DETERMINATION OF PROJECT APPLICATION

WOLLONGONG PRIVATE HOSPITAL

360-364 CROWN STREET AND 9-11 URUNGA PARADE, WOLLONGONG

(MP07_0070)

GENERAL ARRANGEMENT PLAN - BASEMENT LEVEL 1  
SCALE 1:200

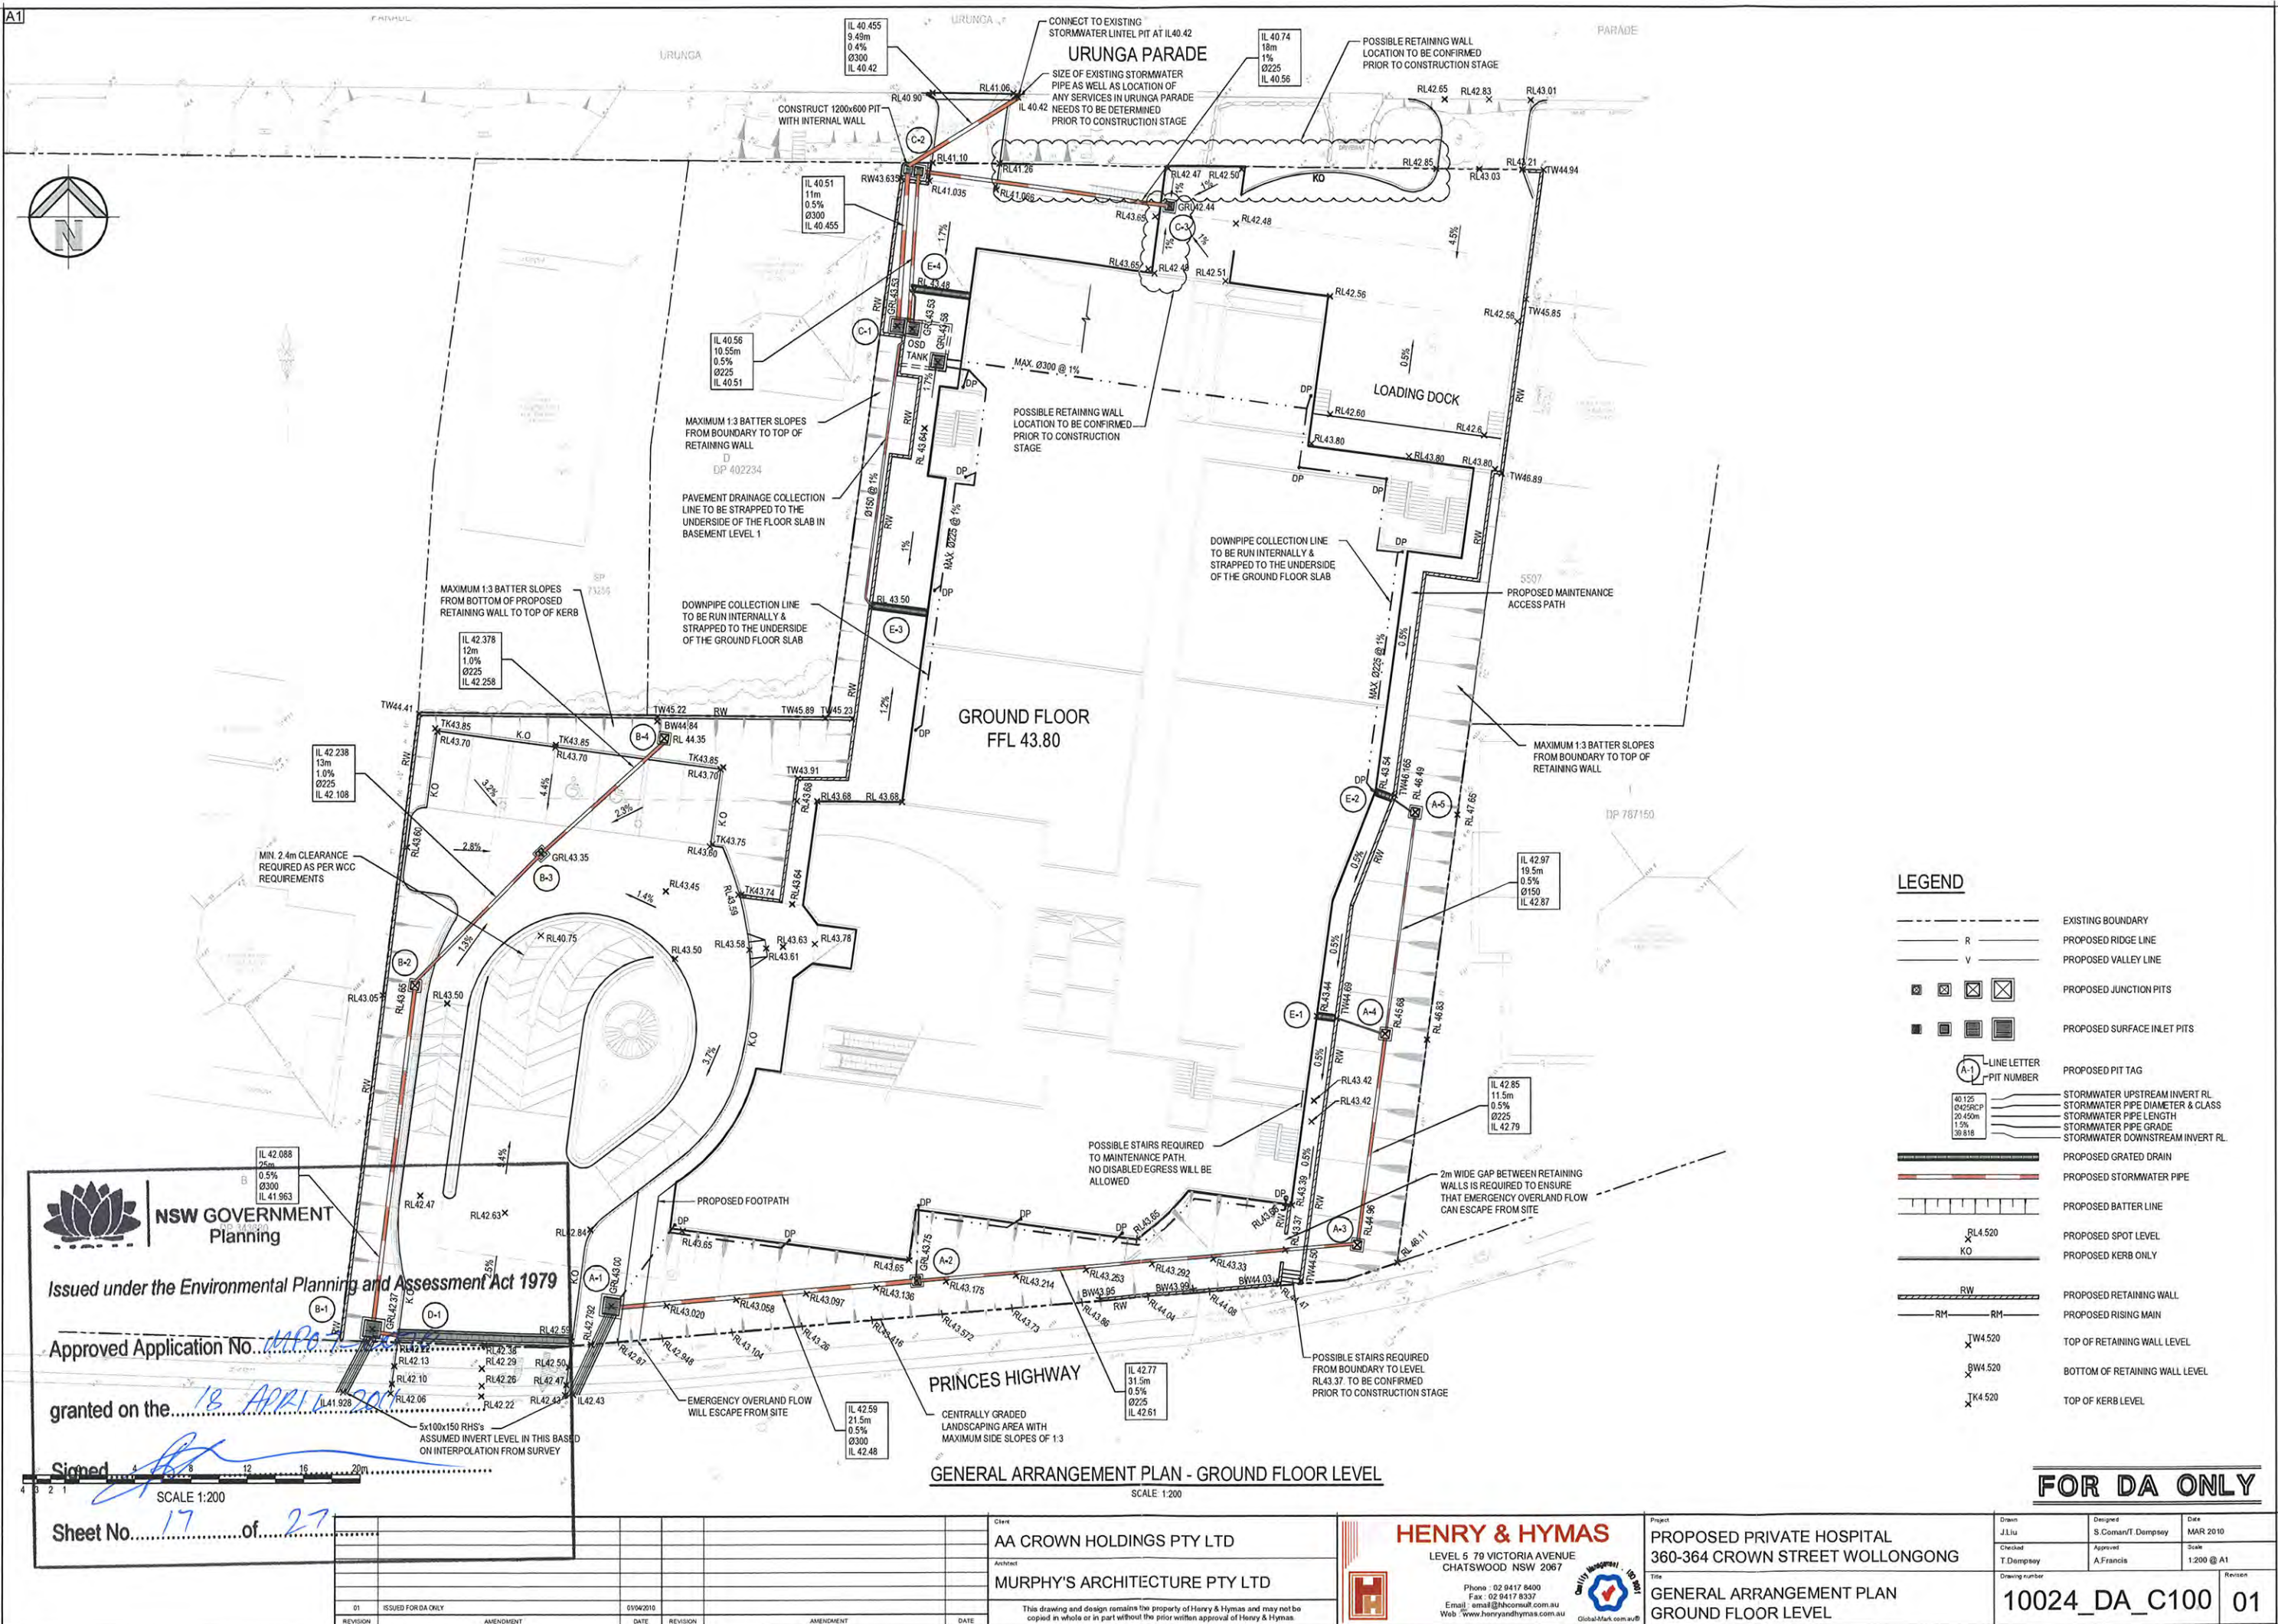
To improve queuing space available towards Crown Street and increase the number of cars that are able to exit the site per signal phases, the following amendments to the locations of the Crown Street car park entry/exit boom gates are required:

- (a) The Crown Street car park entry boom gate is to be relocated further east as far as possible, deleting parking spaces 87 and 88 in order to maximise queuing space;
- (b) The Crown Street car park exit boom gate is to be relocated a further two car lengths into the site, adjacent parking space 79 (proposed accessible space) to increase the number of vehicles that are able to exit the site per signal phase; and
- (c) The relocation requirement of the exit boom gate results in vehicular circulation on Basement Level 1 being restricted. In addition to the design amendments required in accordance with Conditions B8(a) and (b), provision is to be made within the car parking layout of Basement 1 to ensure that vehicular circulation is maintained.
